REQUEST

Current Zoning: R-3 (single family residential)
Proposed Zoning: NS (neighborhood services)

Approximately 0.99 acres located at the southeastern corner of the intersection of Steele Creek Road and Rigsby Road.

The petition proposes to allow the development of a 4,000 square foot commercial building with accessory drive-through for all uses permitted in the NS zoning district.

RZ1.0

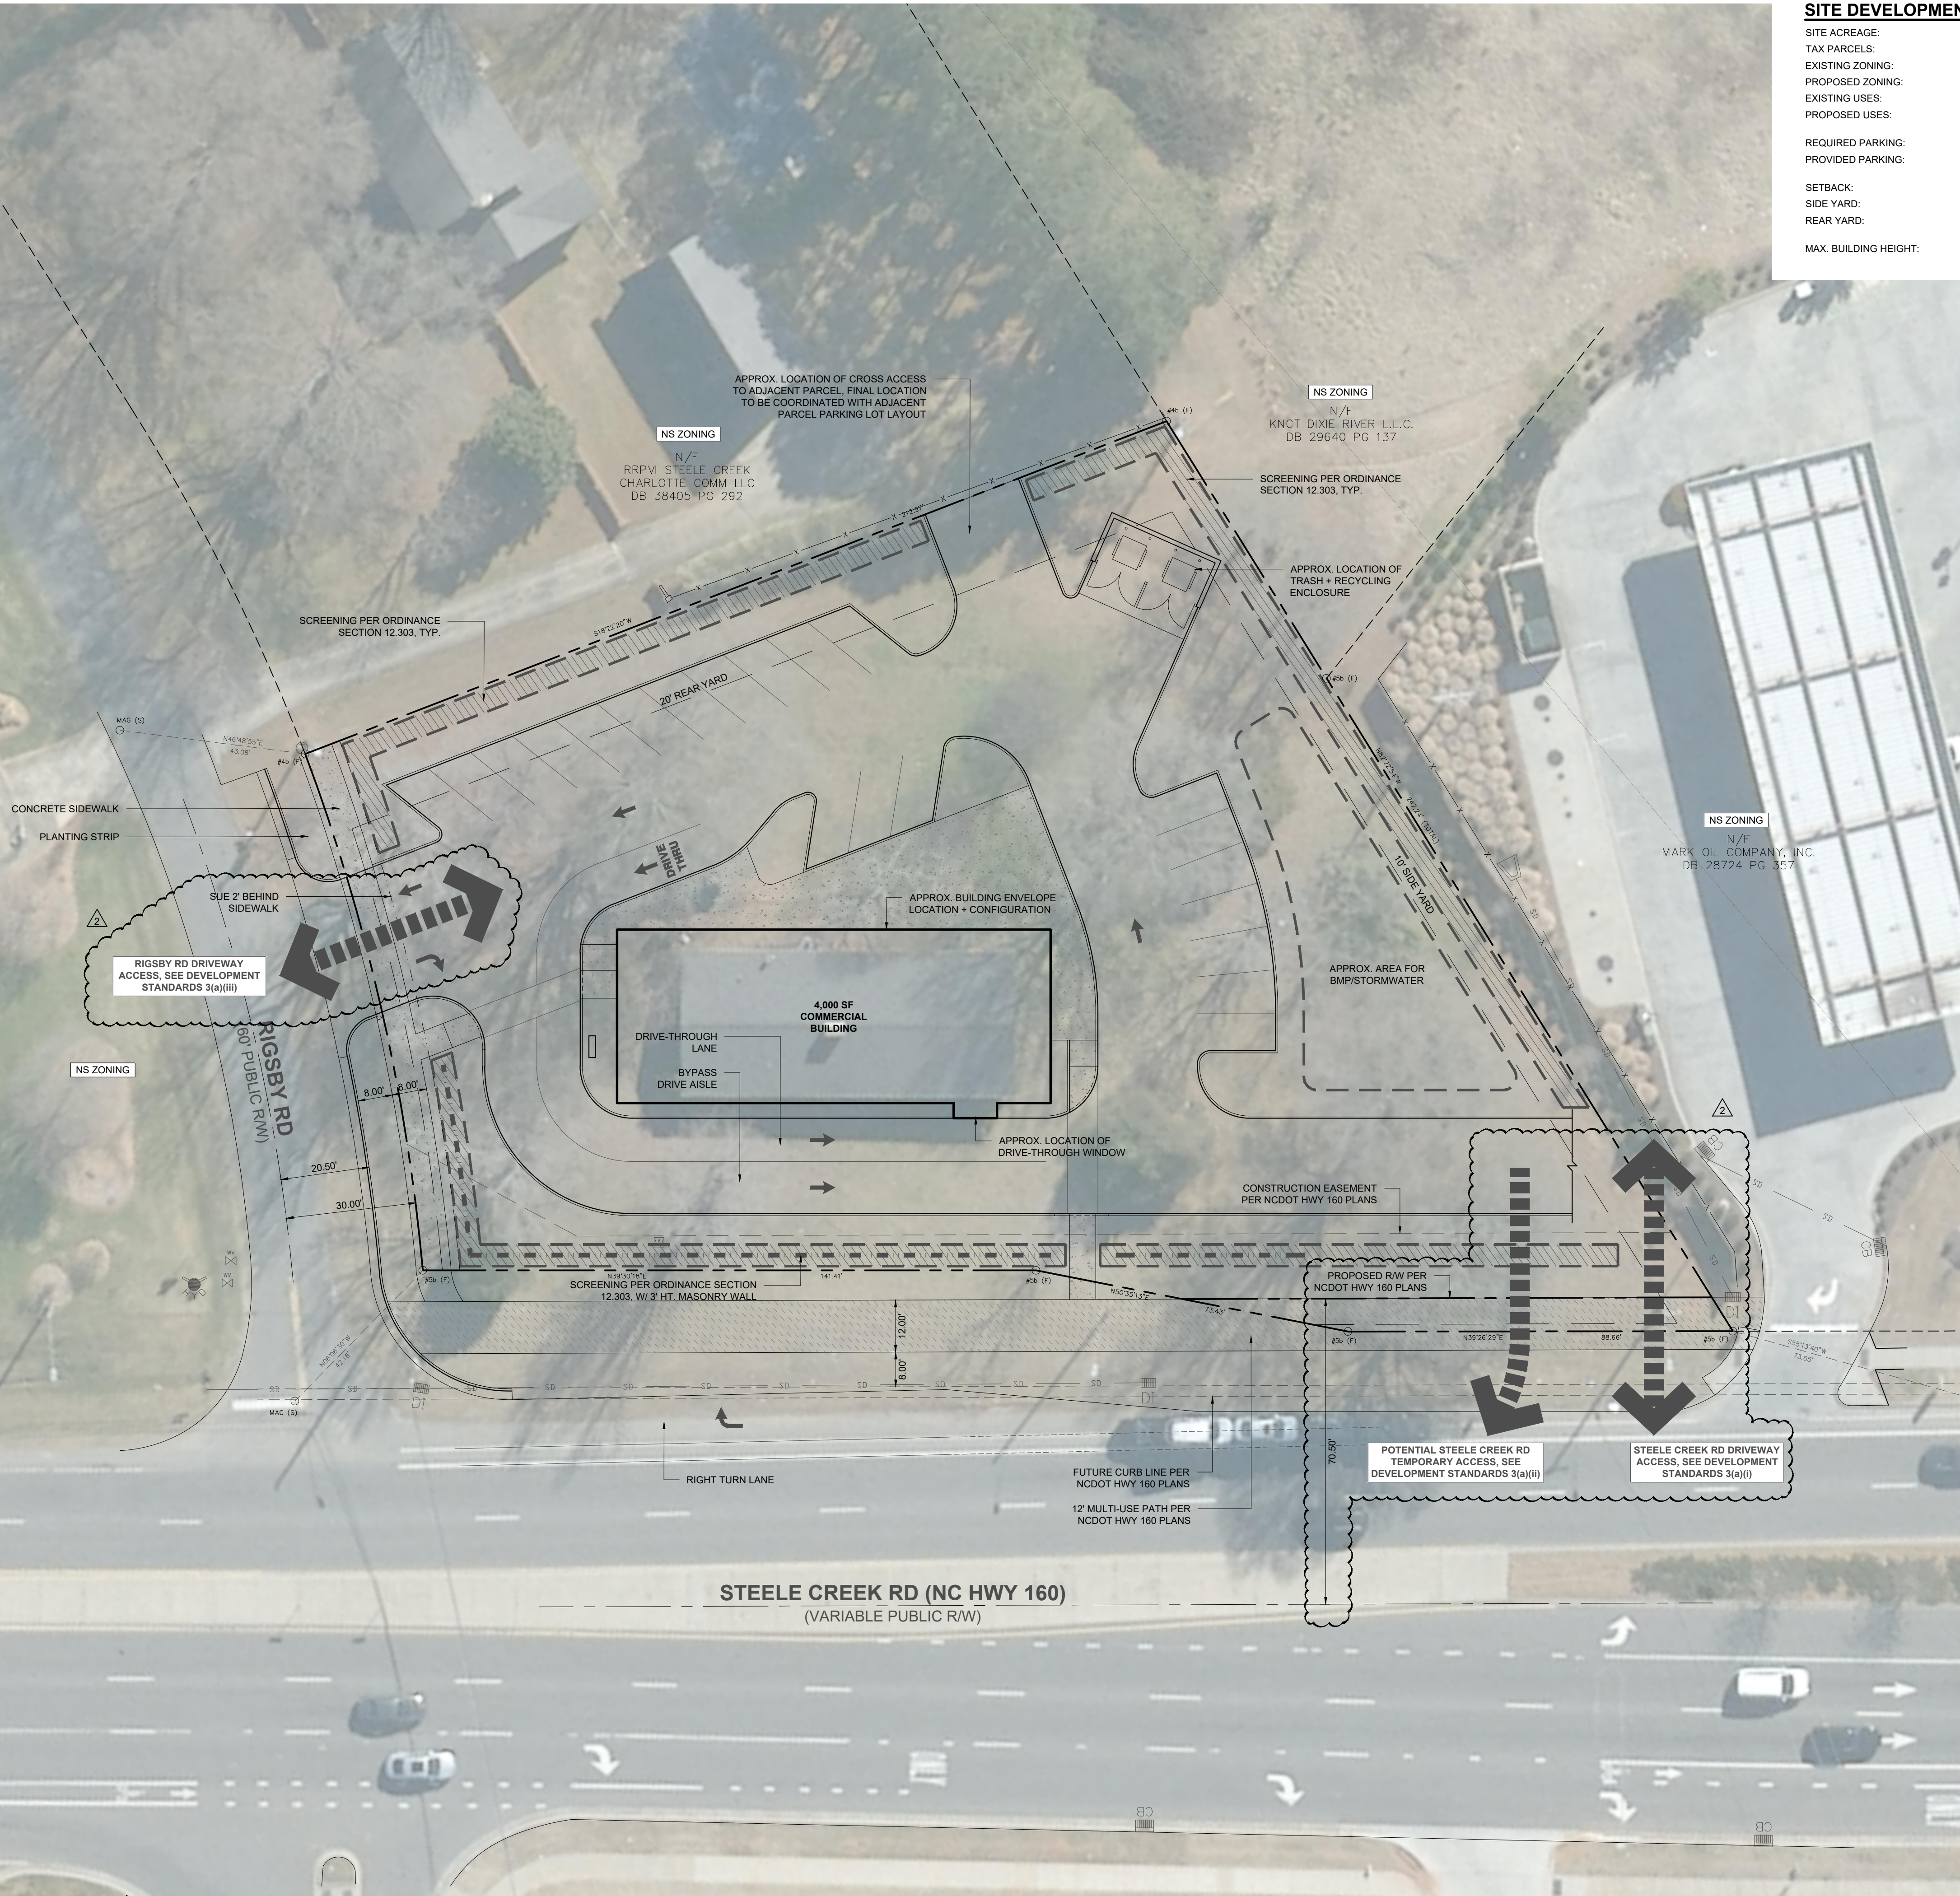
1. Label and dimension the rights-of-way from centerline of Steele Creek Road and Rigsby Road.
2. Place a sidewalk utility easement 2' behind the sidewalk along Rigsby Road.
3. Revise the conditional notes by committing to provide an access easement, during permitting, with PID 20109114 to allow cross-access as generally shown on the site plan.
4. Revise the site plan by clarifying the 6-foot dimension on the site's frontage of Steele Creek Road.
